From: Bowie, David [REDACTED]
Sent: 19 July 2022 16:53
To: Thomas Moloney <>
Cc: Simon Davis <Simon.Davis@arun.gov.uk>; Planning SE [REDACTED]; Lisa Jackson <>; Cleaver, Elizabeth [REDACTED]; Ngobi, Diana [REDACTED]; [REDACTED] Bown, Kevin [REDACTED]; SouthEast [REDACTED] Spatial Planning [REDACTED]
Subject: RE: National Highways response: Y/3/22/OUT, Land West of Bilsham Road, Yapton

For attention of:	Mr Thomas Moloney
Site:	Land West of Bilsham Road Yapton
Proposal:	Hybrid Application comprising of: Outline planning application for further phases of up to 110 No dwellings and associated infrastructure (with all matters reserved) and Full application for Phase 1 for 30 No residential dwellings, new access from Bilsham Road, public open space, landscaping, sustainable urban drainage and associated works. This application is a Departure from the Development Plan and is in CIL Zone and is CIL Liable as new dwellings.
Your Reference:	Y/3/22/OUT
National Highways' Reference:	93768 #17191(SB379)

We have received your technical note A361-TN008 and associated plans following our earlier correspondence with yourself and Arun District Council regarding the detail of the Transport Assessme

Appendix C – A27 Mitigation Scheme

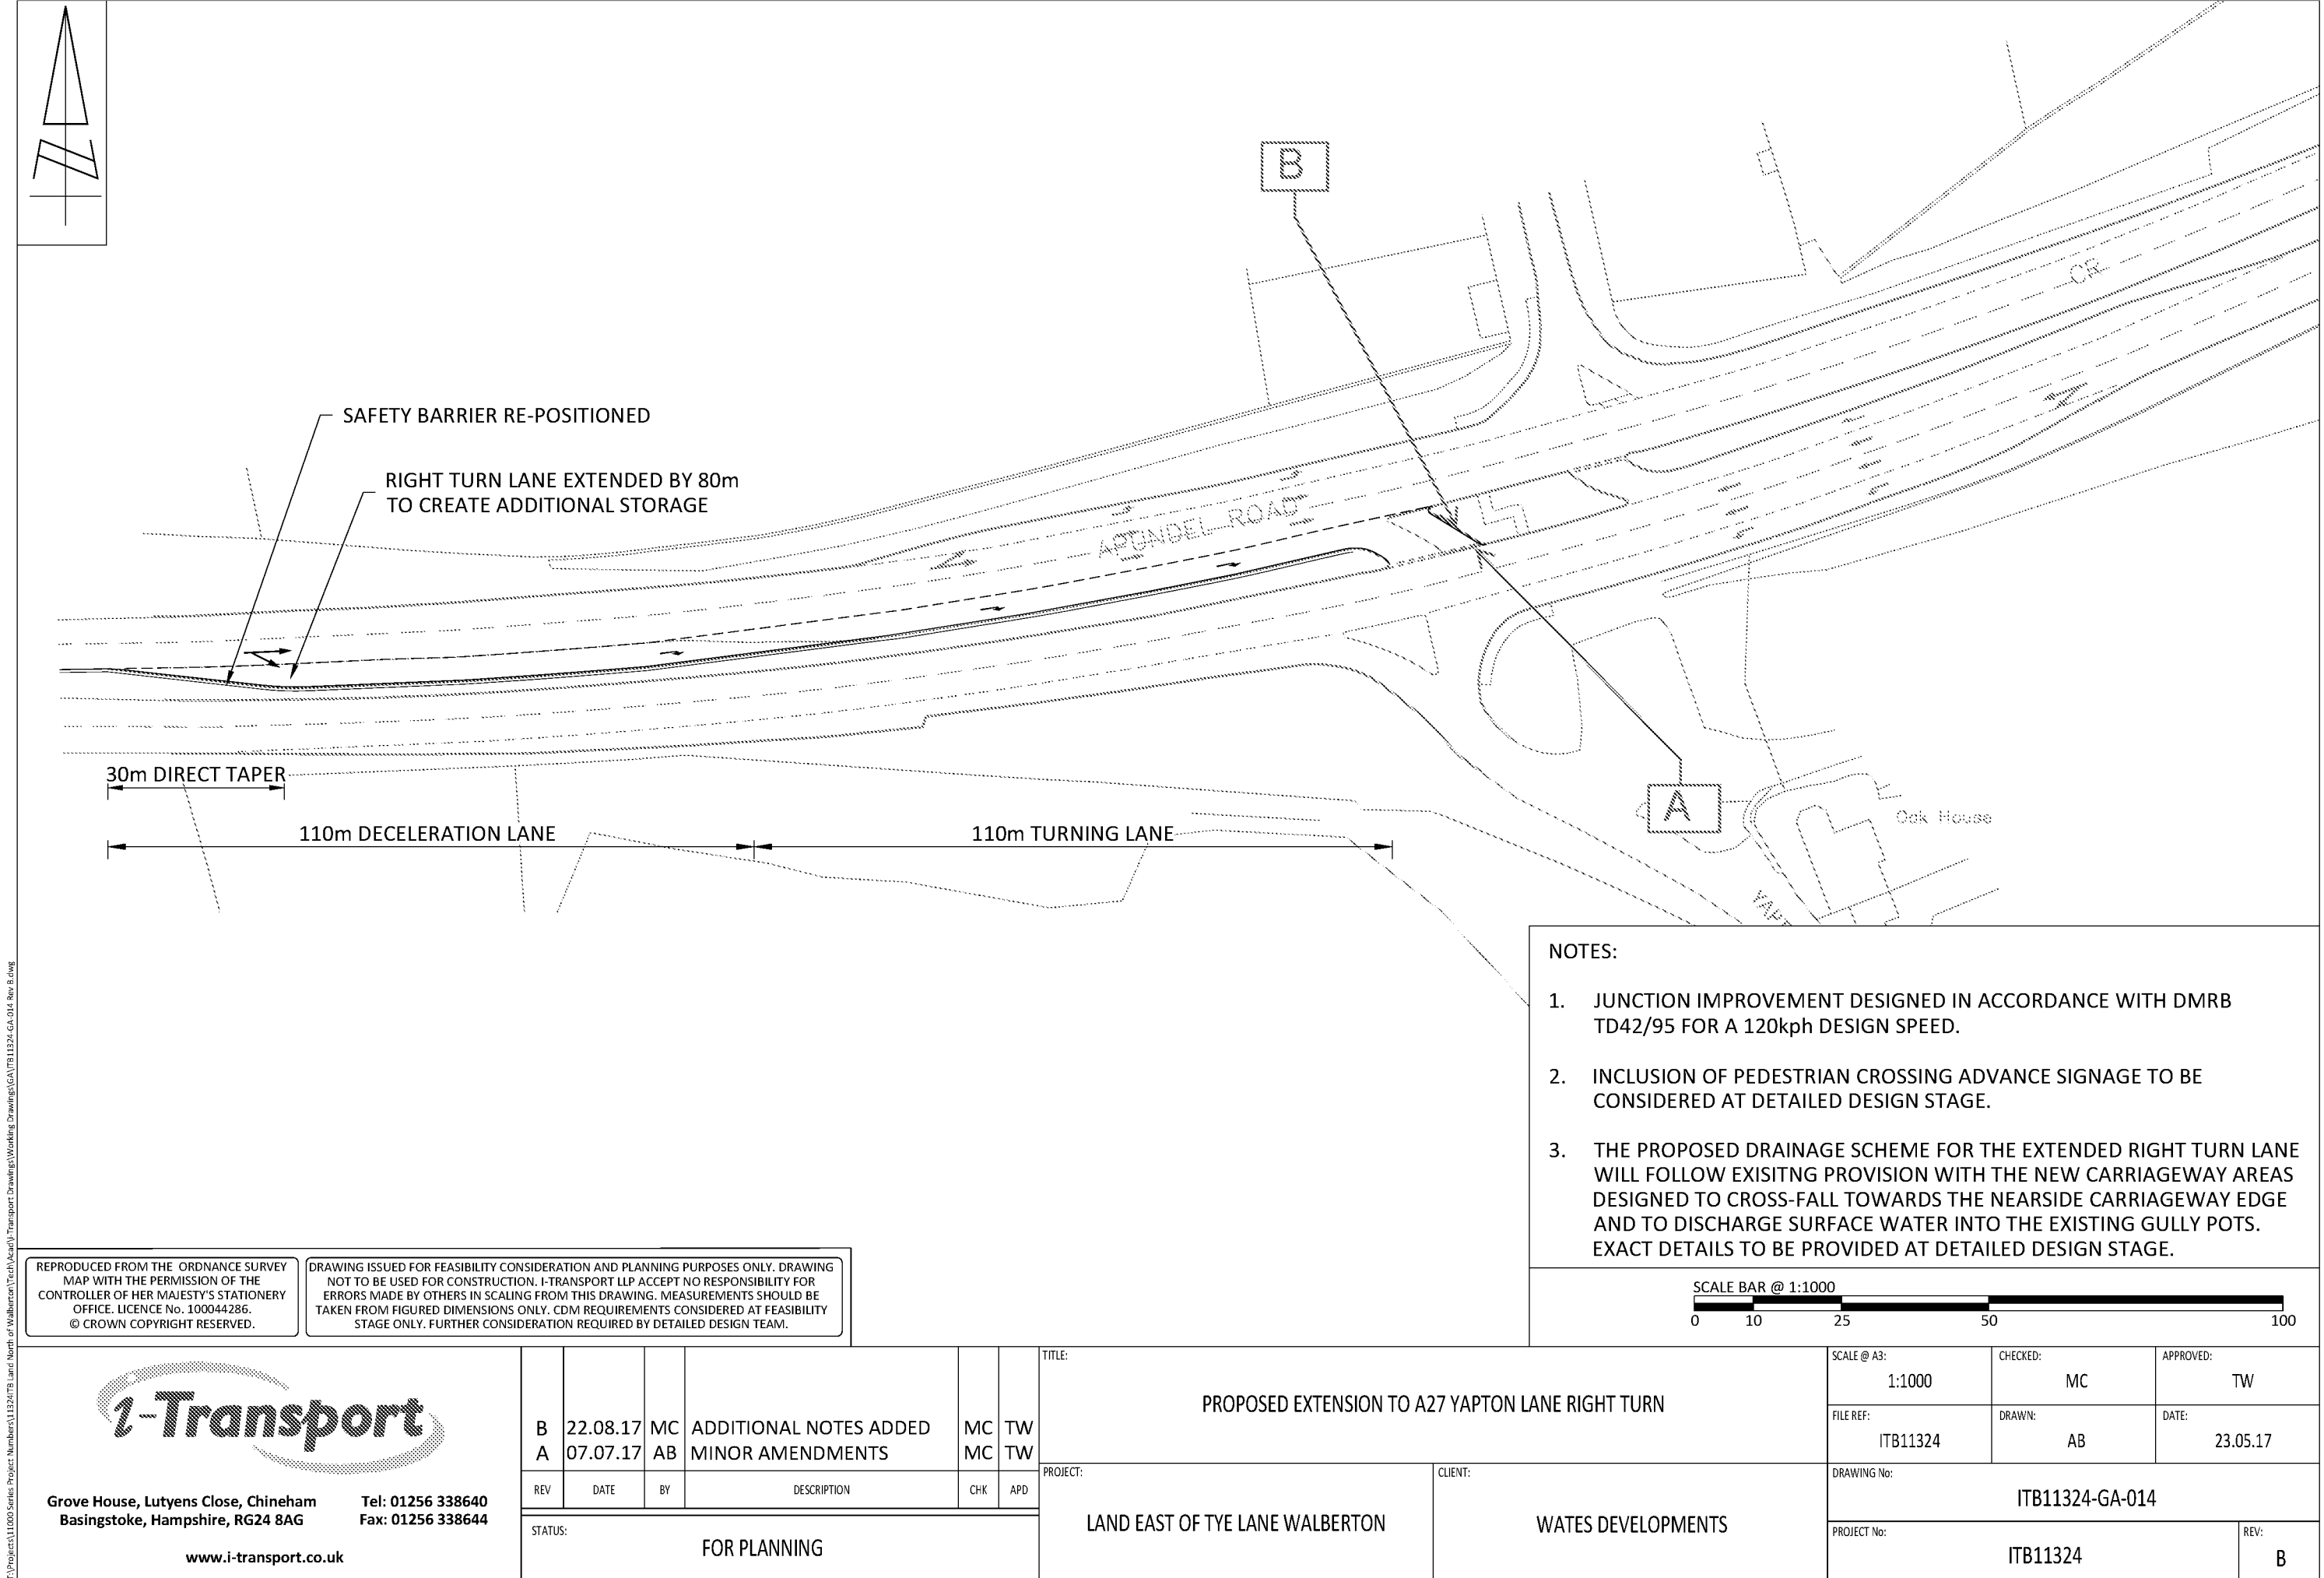
We observe that the model outputs for the improvement scheme layout have only been provided for the PM peak period; the outputs for the AM peak period also need to be provided so that the general performance of the improved junction in this period can be verified.

ACTION: AM peak model files for the improvement scheme layout as shown on drawing number ITB11324-GA-014 Revision C need to be provided.
